## **Community Environment Network Inc.**

3<sup>rd</sup> October 2020

### **Mixed Use Development at 8 – 16 Watt Street, Gosford (Gateway site) (SSD-10414)**

## 6. Burns Place Park

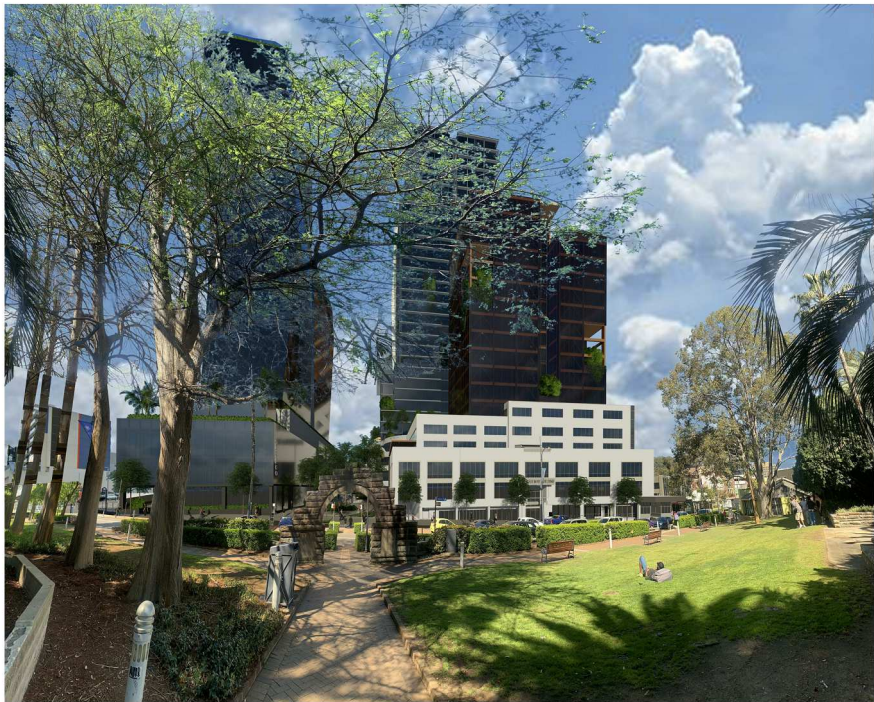
Burns Place is one of the key public open spaces in the City Centre and it would be 51 % overshadowed at 9 am in mid-winter, but it would be shadow-free by 11 am. The overshadowing would be worse at the equinox because the sun is more easterly in the morning than in mid-winter. The lack of shadow diagrams for the equinox makes it impossible to assess this impact.

View From Faunce Street

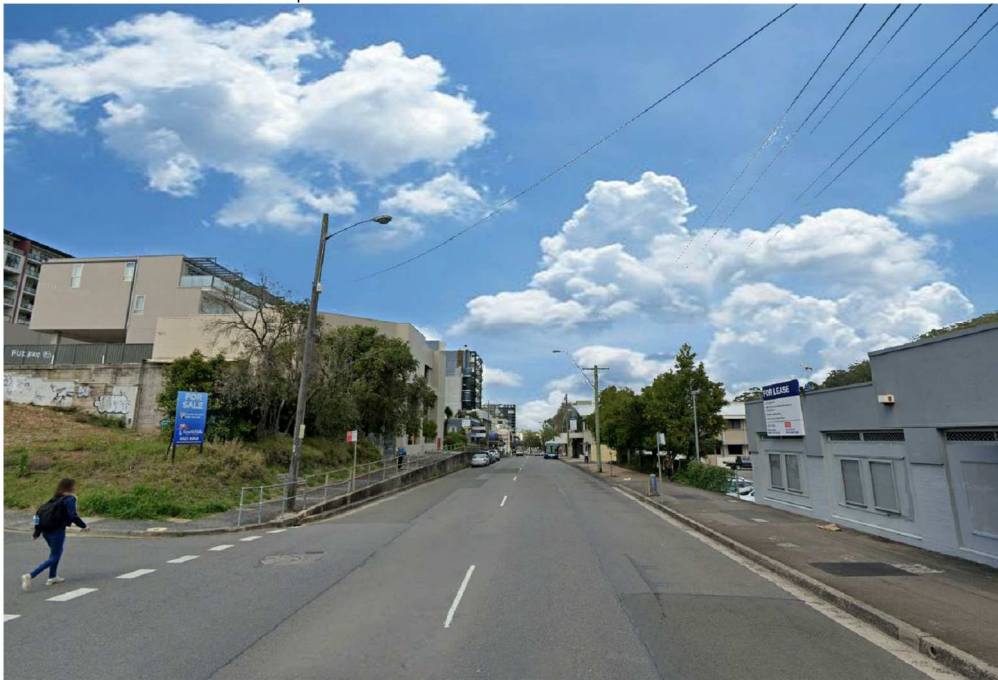
Similarly, from the eastern end of Faunce Street (east of Watt Street), there is a vista of Presidents Hill, which would be obscured by the proposed development. This is demonstrated by View Analysis 7 in the Visual Impact Analysis (Appendix O), in which the photomontages are taken from the Faunce Street intersection with Watt Street.
